**From:** [Brown, Timothy J.](#)  
**To:** [Terry Brown](#); [Ron Bohannon](#); [Haynes, Margaret, DOT](#)  
**Cc:** [Armijo, Ernest M.](#); [Jon Niski](#); [Sergio Lozoya](#)  
**Subject:** RE: [#2023123] - Mountain Rd. Rehab Center (Mountain Rd. / I-25)  
**Date:** Wednesday, June 18, 2025 11:36:35 AM  
**Attachments:** [image004.png](#)

Apologies, I thought I sent this last week. I've completed my review of the Crash Analysis memo. I have the following comments:

The graphical representation of the preceding table follows:

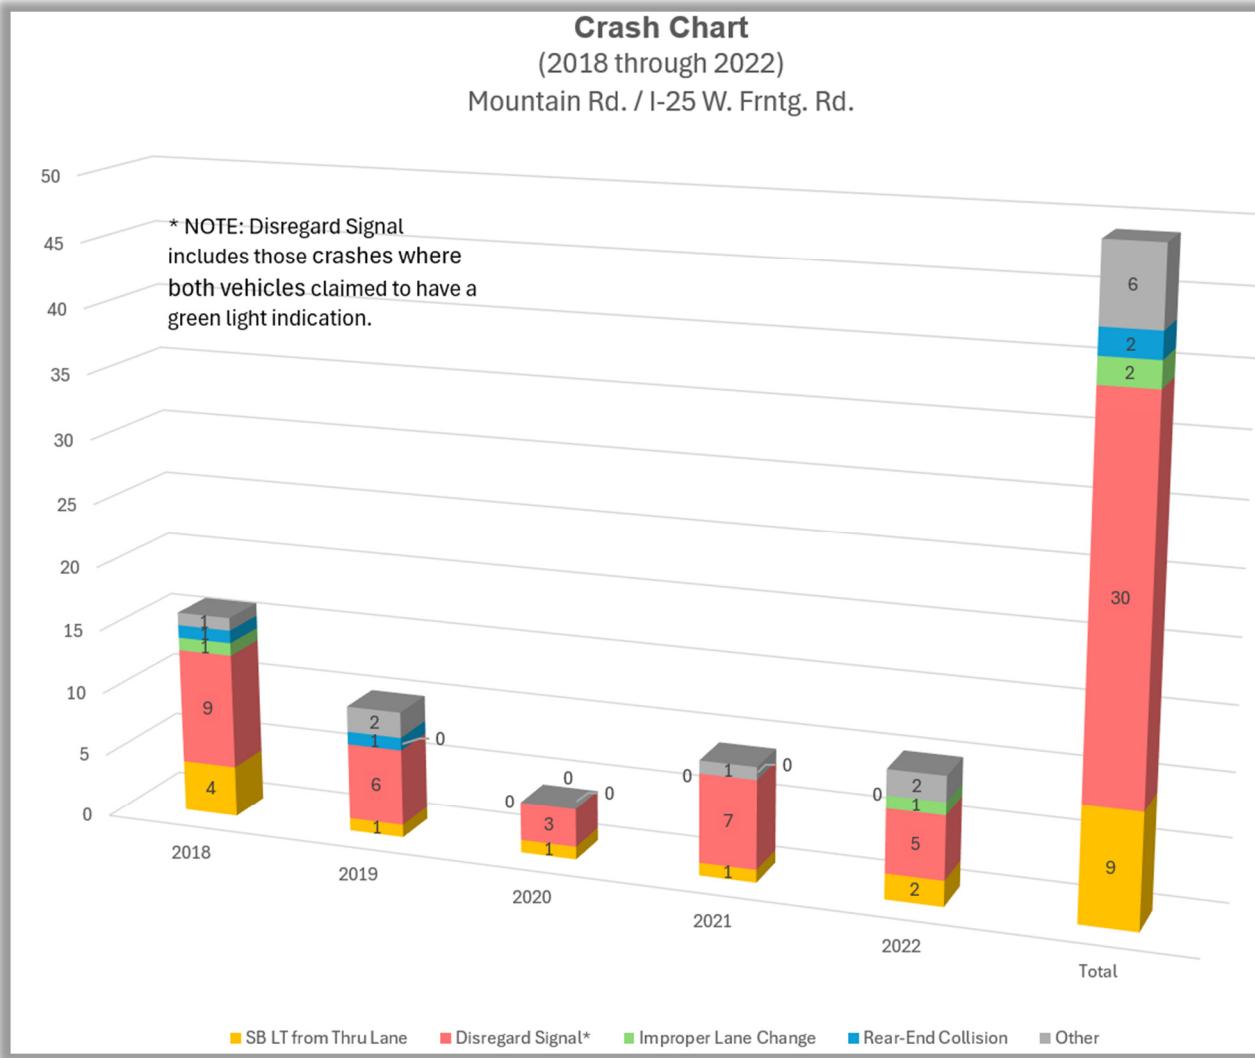
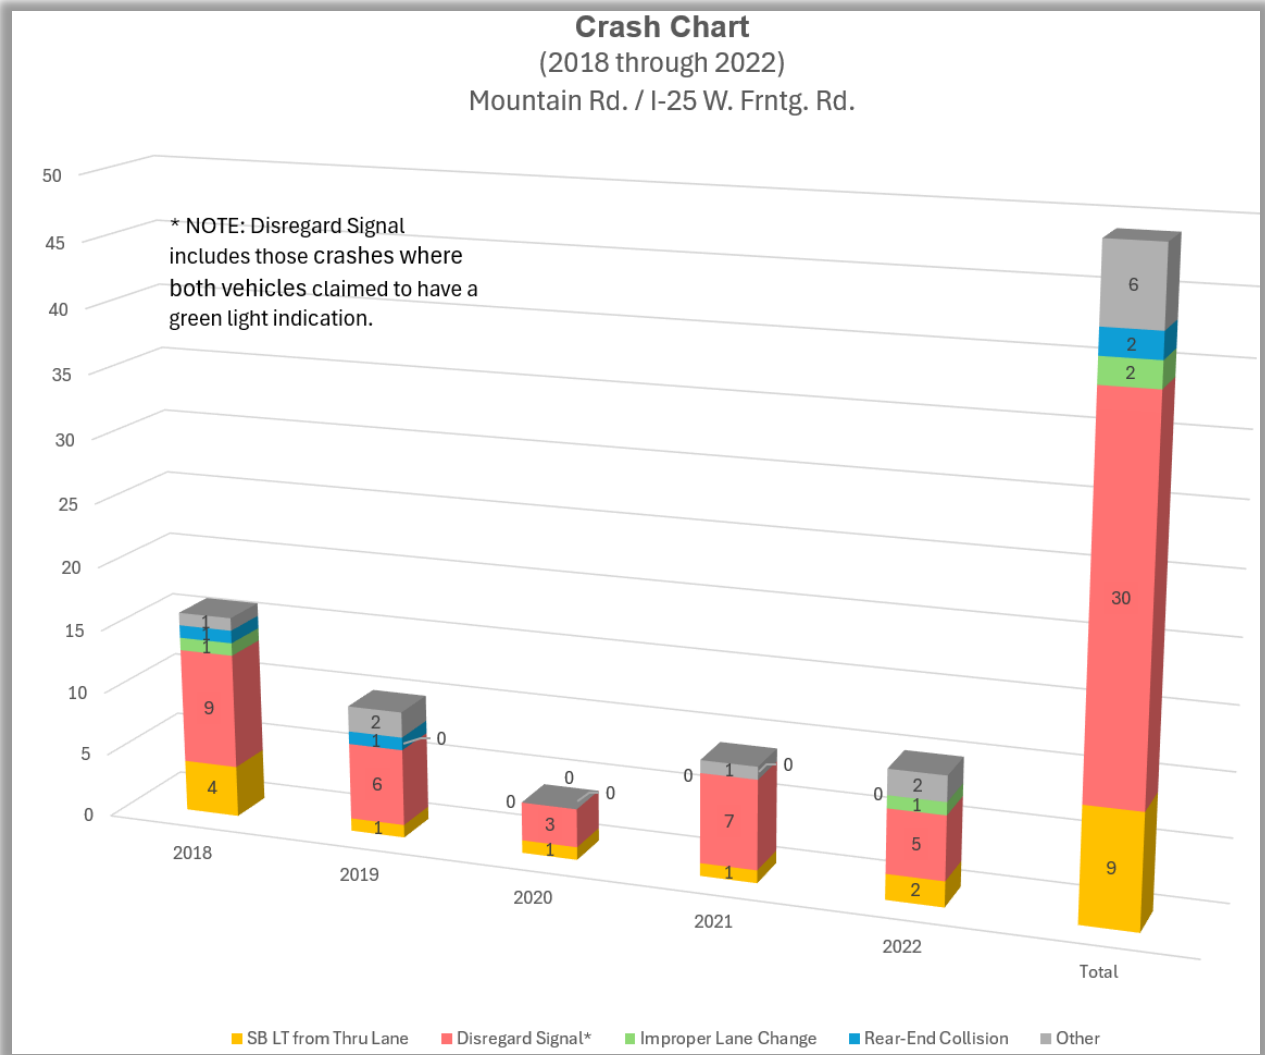
3. The crashes devolved into two principal types:
  - a. Left-turn from the wrong lane. Very frequent prior to 2020, somewhat mitigated by additional arrow striping done in mid-2020. Still averaging about 1.5 crashes per year. There were also 2 or 3 improper lane change crashes that I felt could be improper turn crashes, but the initiating driver might have been too embarrassed to admit it, and passed it off as an improper lane change.

- b. Red-Light-Running (RLR) crashes. I counted 28(!) of these. This is, by far, the worst RLR location I've reviewed in 25 years of looking at crash reports. 19(!) of them were injury crashes. Unfortunately, drivers run reds from all directions for all reasons, so this is not easily tackled.

1. To fix the turn from wrong lane and sideswipe crashes – make left lane a trap left-turn-only lane for Mountain. This intersection does not need three SB lanes of capacity. It will function fine with two. This could be enhanced by dropping the left lane entirely prior to the intersection, then developing a left-turn bay for the intersection. Also, an ONLY could be placed between the two thru arrows in the center lane, and possibly a double white between those two lanes. The double white could be continued on the south side of the intersection for a 100' or so.
2. To address the RLR crashes – as stated above, they happen in all directions. The following may help:
  - a. Put yellow back plates for all approaches. FHWA likes these. I think they'd be useful

- b. Put directional indications at NB Frontage. This will also help the EB RLR issue.
- c. Add secondary indication on back side of EB mast arm for WB traffic. There is already one near side indication on the right side, adding a second may help with WB RLRs.

- d. Remove existing detection and install new detection capable of running red protect. This can be done with the City's current spec, Iteris Vantage. This operation extends the all-red interval by up to 2.5 seconds, which can allow a RLR vehicle to clear the intersection, or at least be more apparent to side street traffic before they enter the intersection.
